**Re: Gardner Zemke Addition, 6821 Academy Parkway West NE,
Request for Permanent C.O. –Accepted
Engineer's Stamp dated: 01-04-12, (E17/D001)
Certification dated: 09-10-12**

**Re: Gardner Zemke Addition, 6821 Academy Parkway West NE,
Request for Permanent C.O. – Not Accepted
Engineer's Stamp dated: 01-04-12, (E17/D001)
Certification dated: 08-22-12**

Re: Gardner Zemke Addition Grading and Drainage Plan
Engineer's Stamp date 01-04-12 (E17/D001)

C101

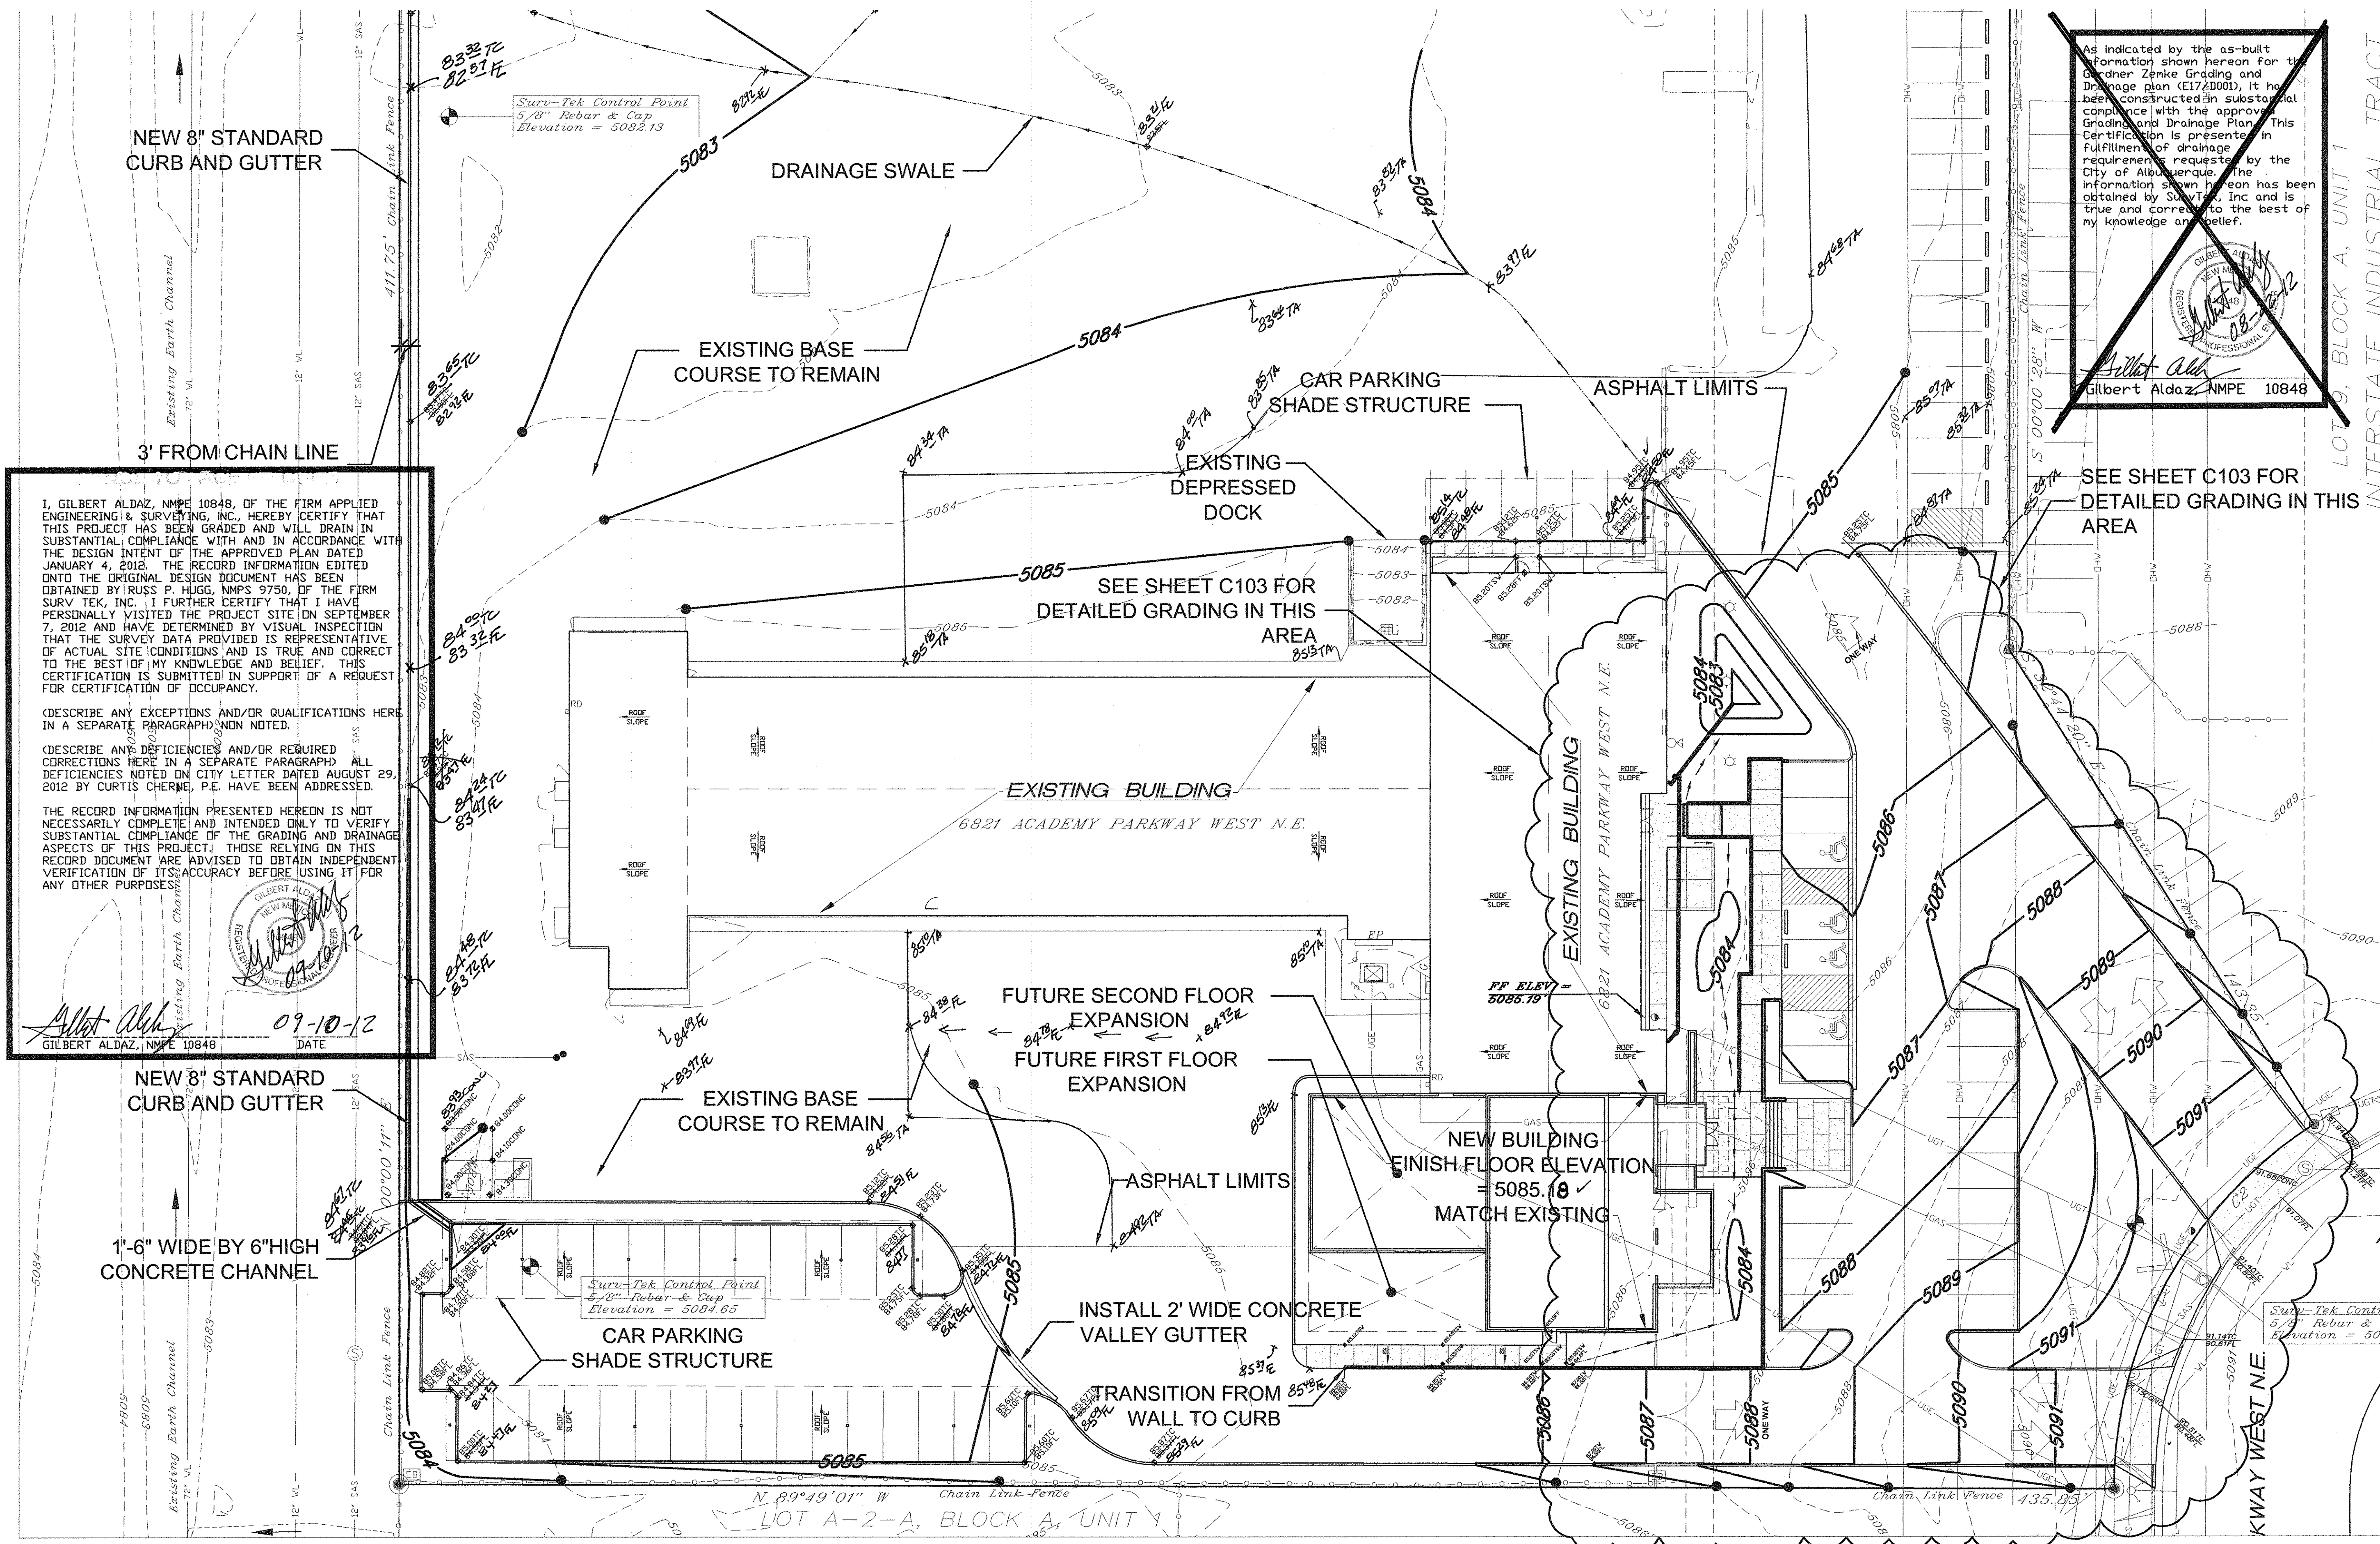
1. It appears a six inch curb was constructed on the western property line in lieu of an eight inch curb. Please provide calculations demonstrating a six inch curb prevents flows from leaving the site.
2. Please certify the pond volume.
3. The Engineer's certifying language will need to be per the DPM, see enclosed.
